Green Hill Solar Farm

EN010170

SCOPING OPINION:

Case Reference: EN010170

Title: Figure 3.2.1 Cable Route Search Area North

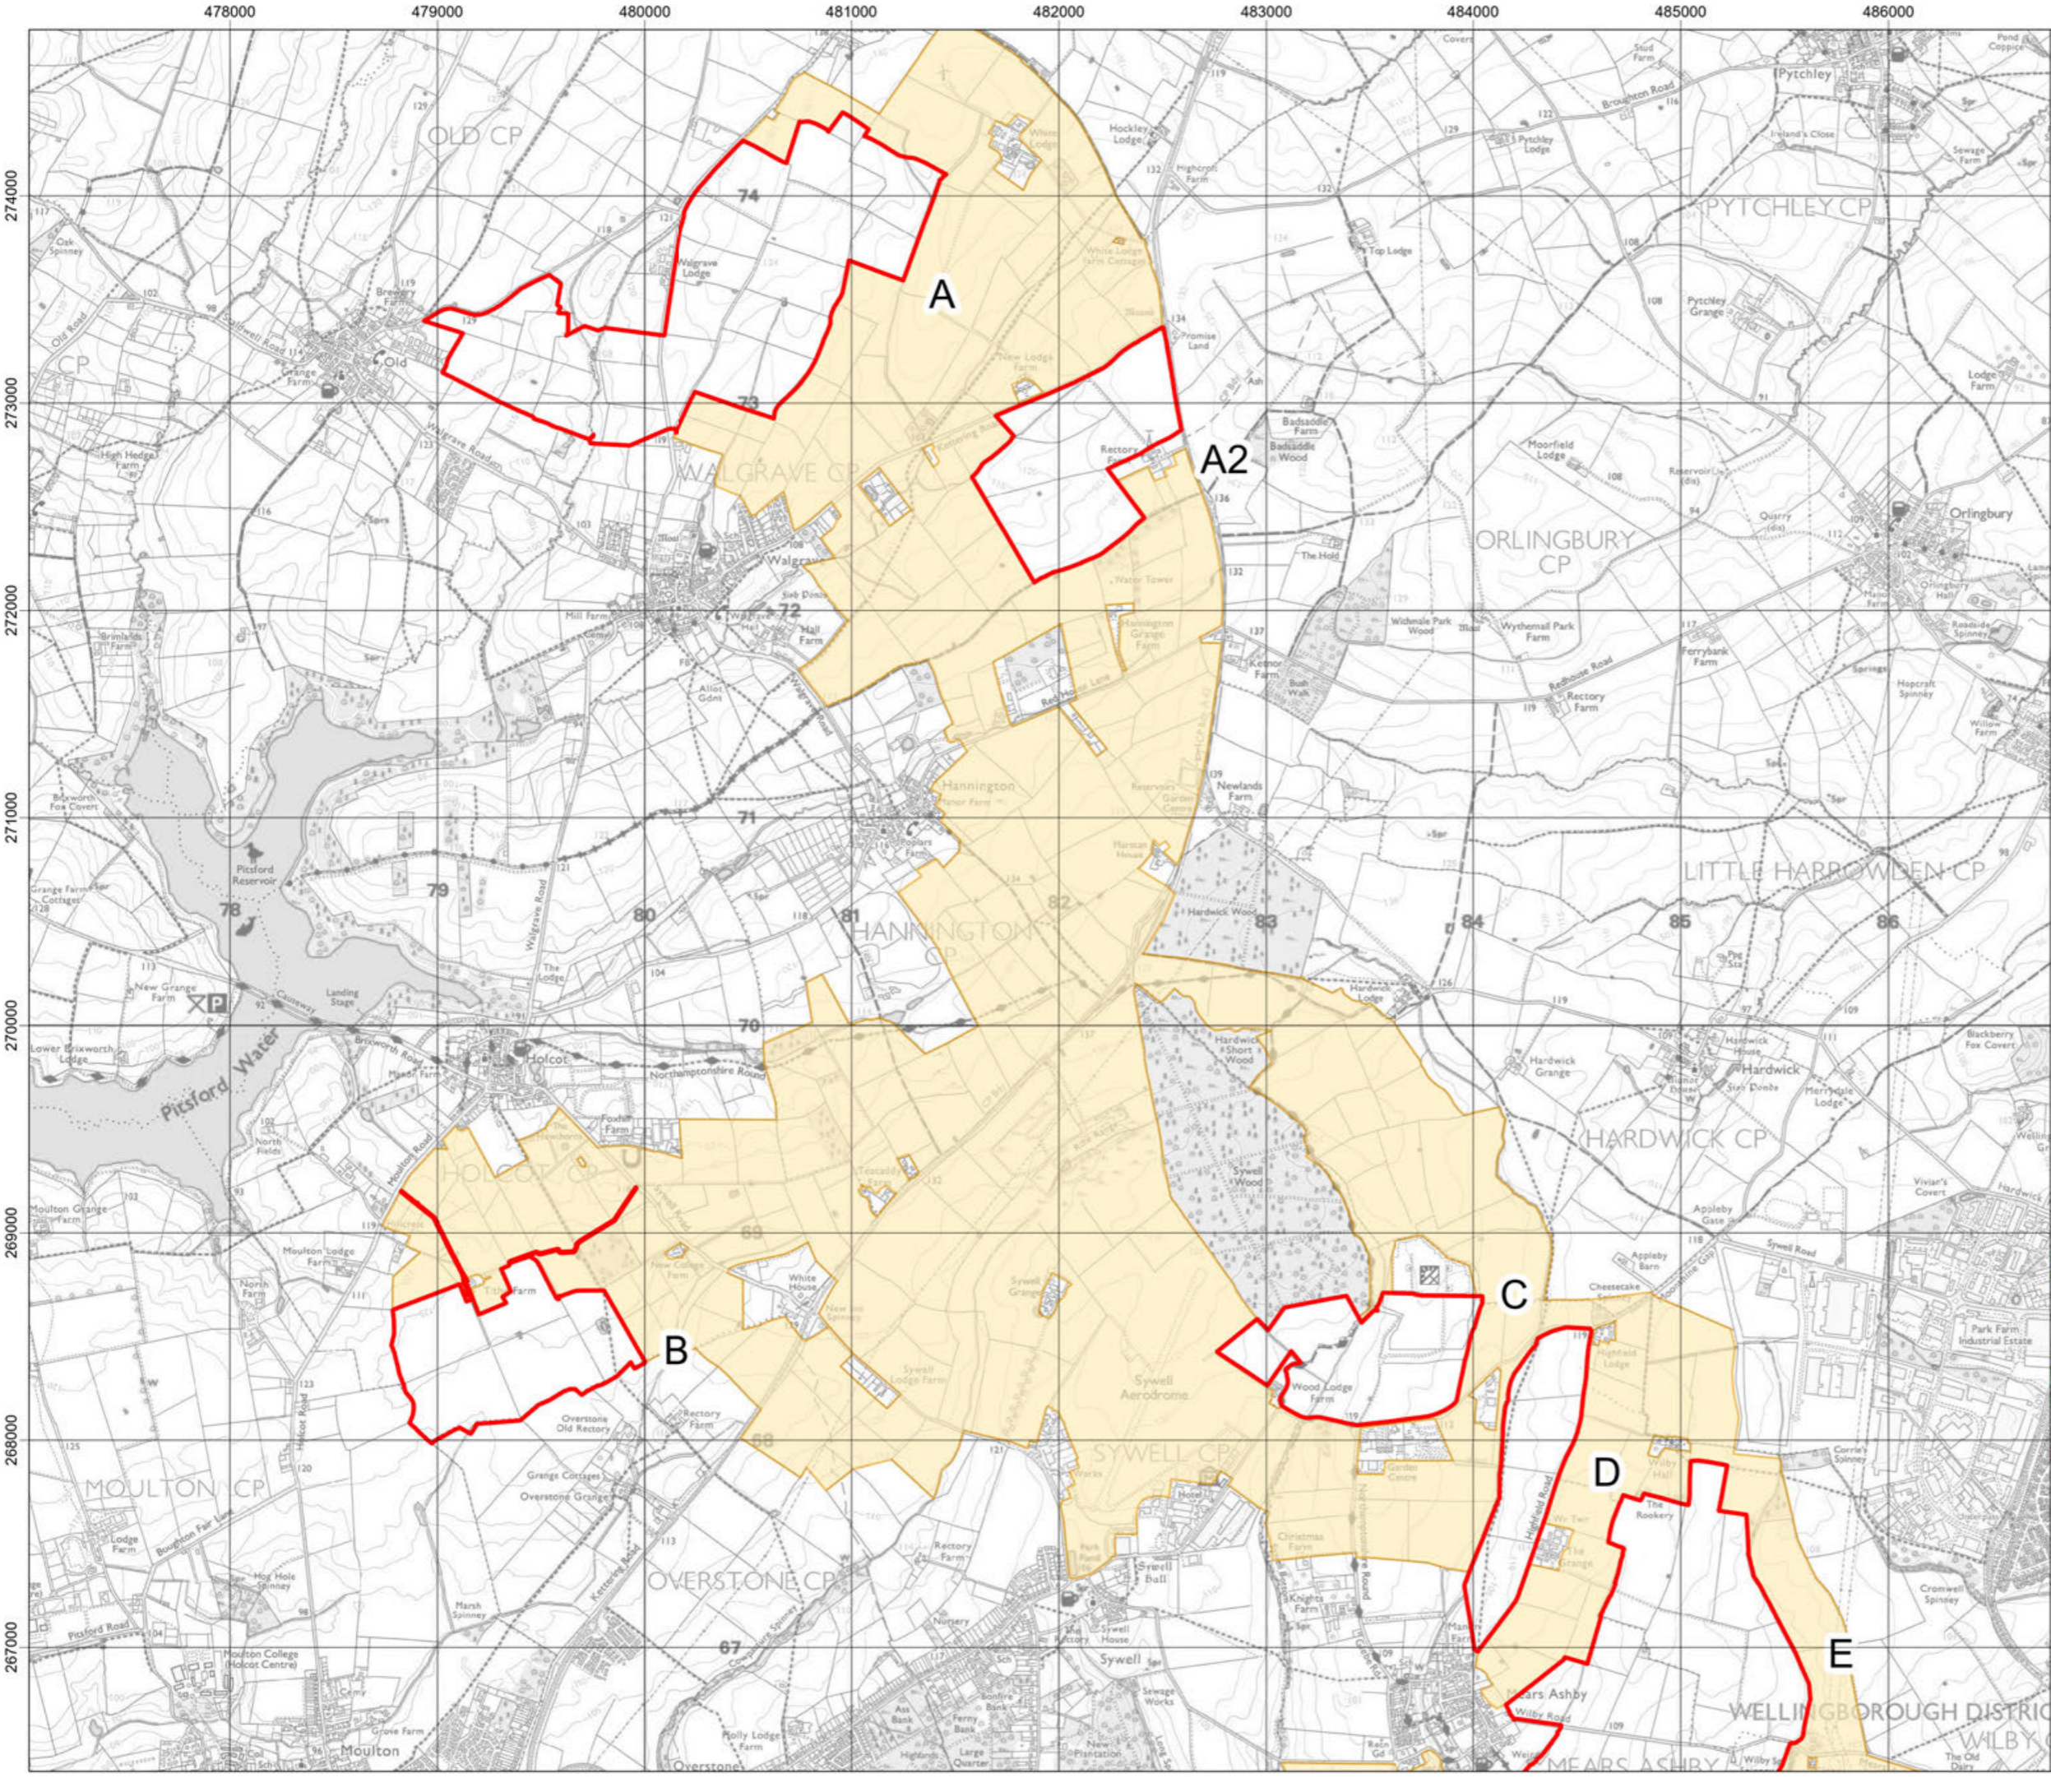
21.14		Figures – red line boundary	The Inspectorate notes that in figures provided the red line boundary denotes only the site areas that contain the solar panels and AD; and the Cable Route Search Area is hatched separately. The red line boundary depicted on the ES figures should encompass the entire application site, ie Sites A – G, the BESS site and the Cable Corridor.

Title: Figure 7.1 Study Area

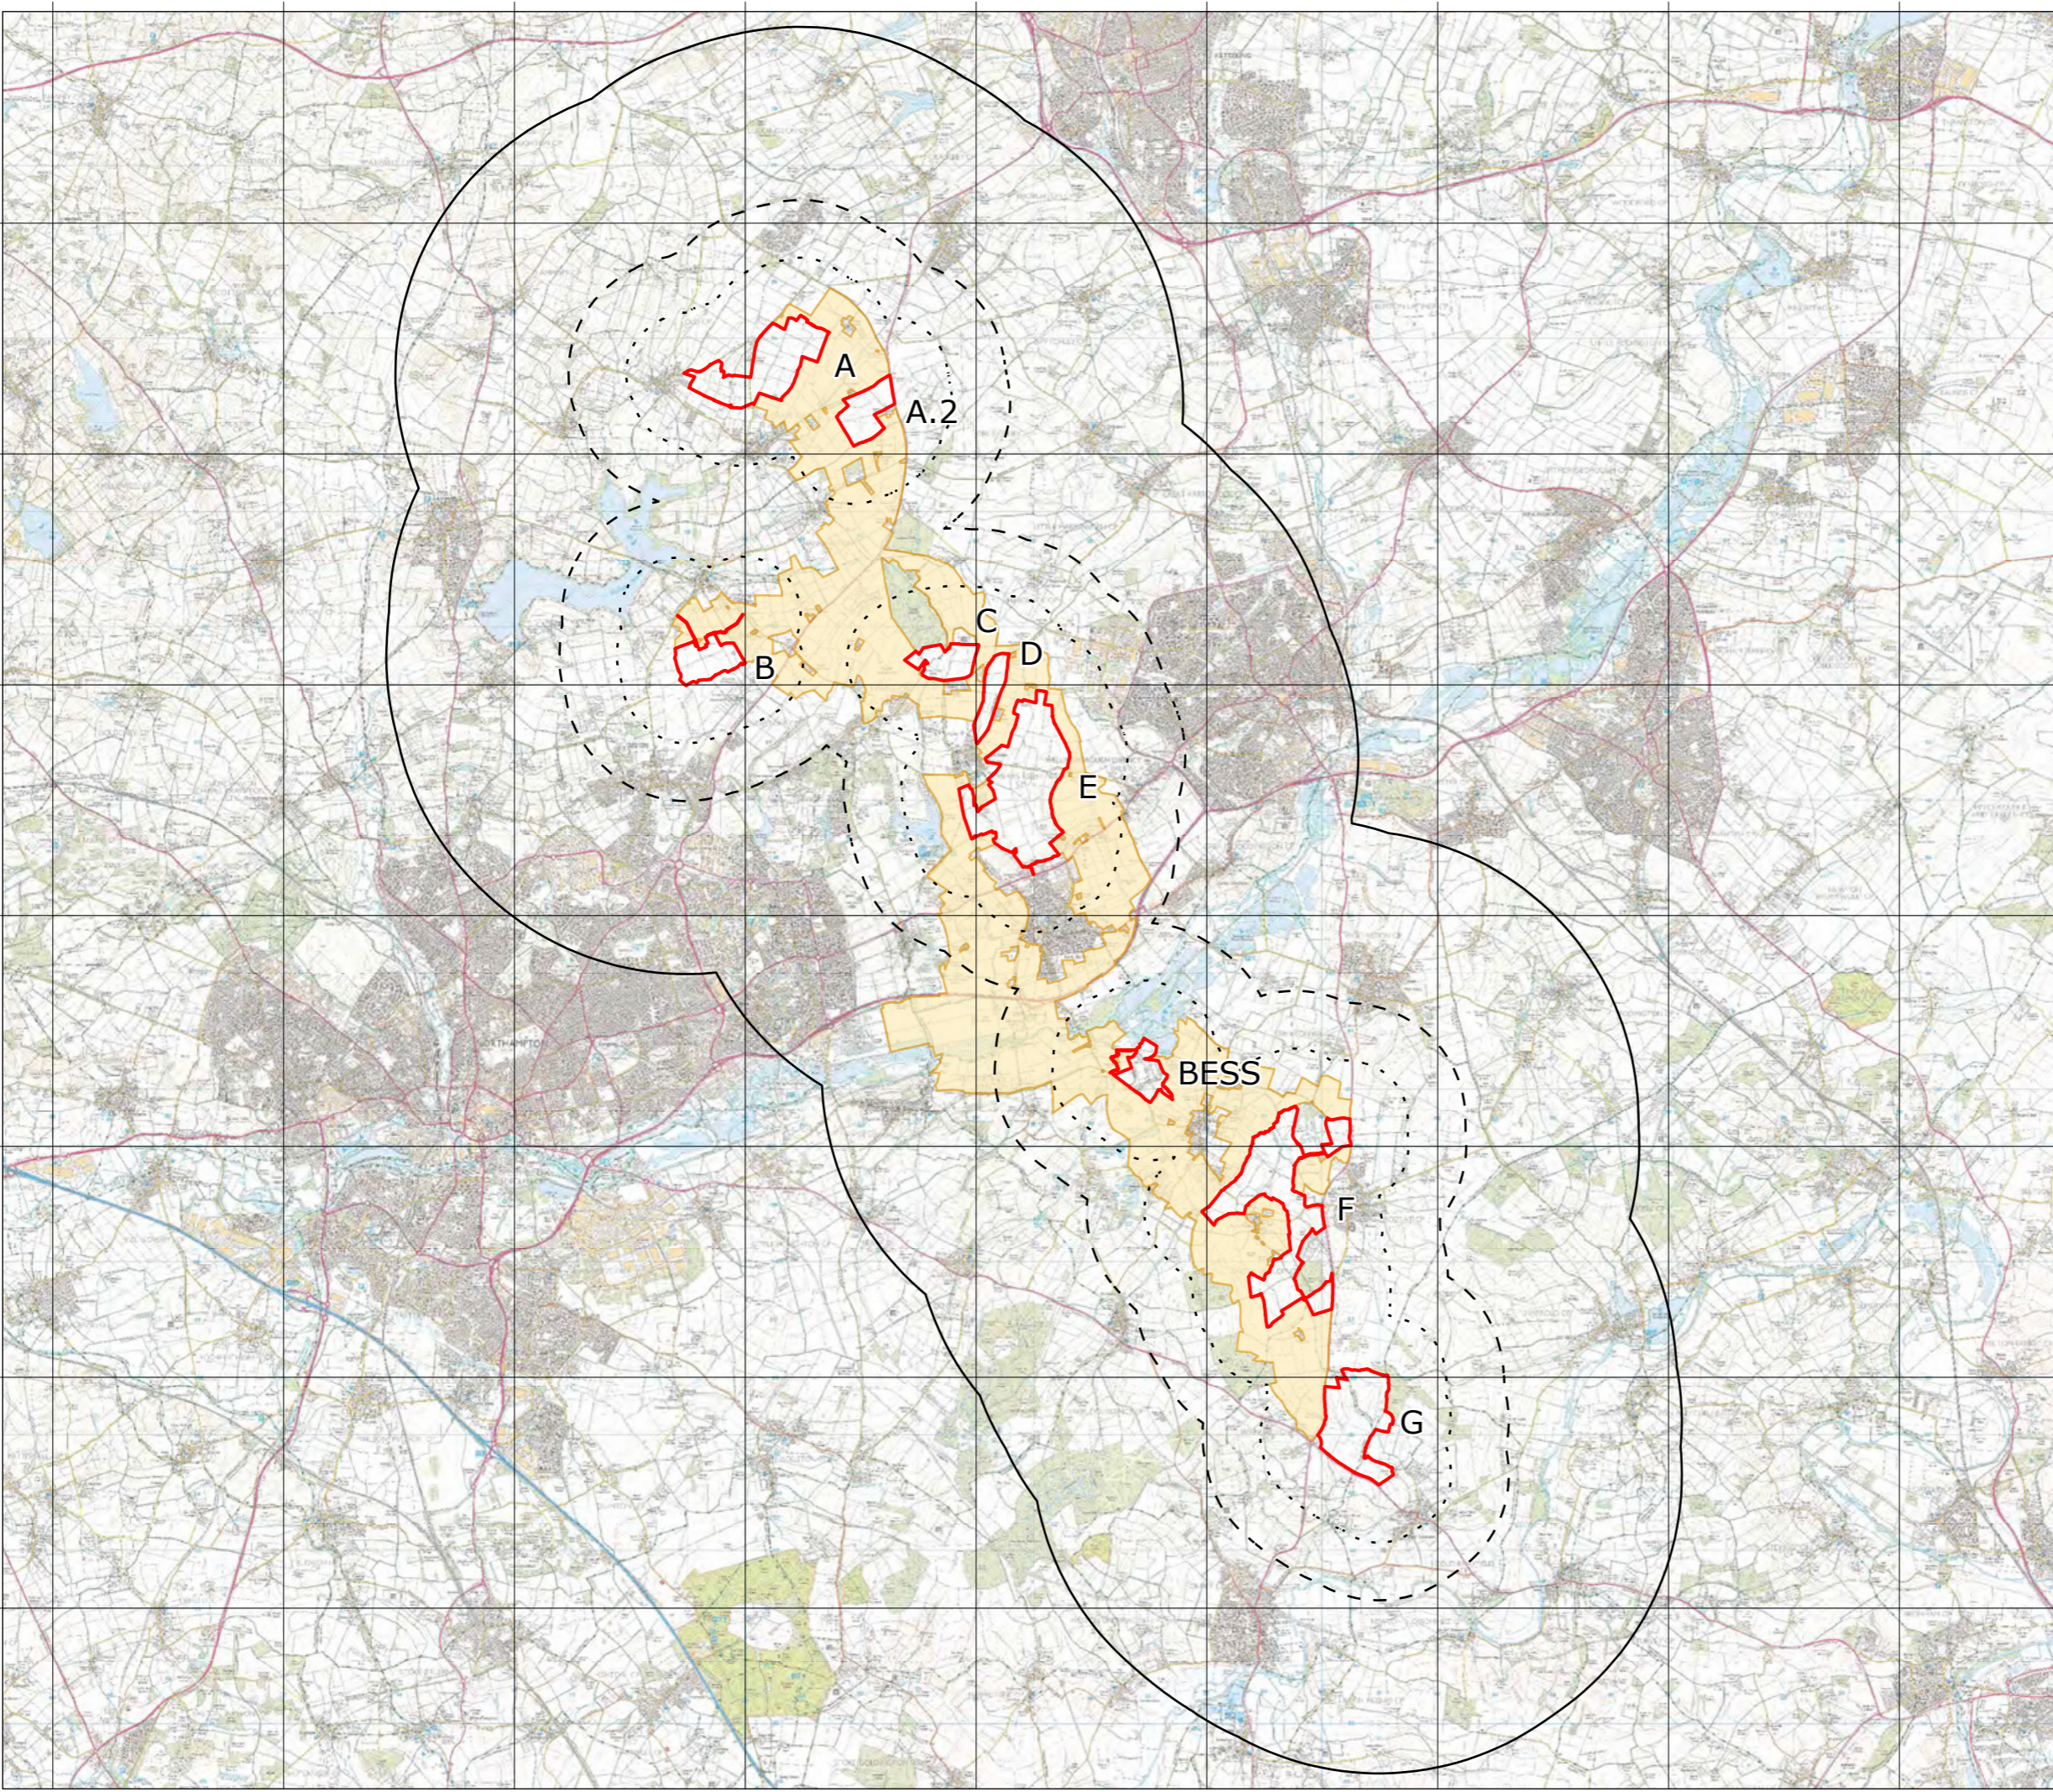
324	Table 7.7	Visual receptors between 2km and 5km outer study area	As indicated in ID 3.2.2 above, the Inspectorate is unable to confirm that the identified receptors can be scoped out due to the study area not considering the whole of the Proposed Development. The Scoping Report states that effects on visual receptors beyond 2km are expected to be negligible given expected visibility. However, the ZTV illustrated in Figures 7.8 to 7.9.8 show that the panels will be visible beyond 2km. The ES should assess potential effects on views and visual amenity within the ZTV where significant effects are likely to occur. In the absence of information such as evidence demonstrating clear agreement with relevant statutory bodies, the Inspectorate is not in a position to agree to scope these matters from the assessment. The ES should include an LVIA supported by a ZTV, or the information referred to demonstrating
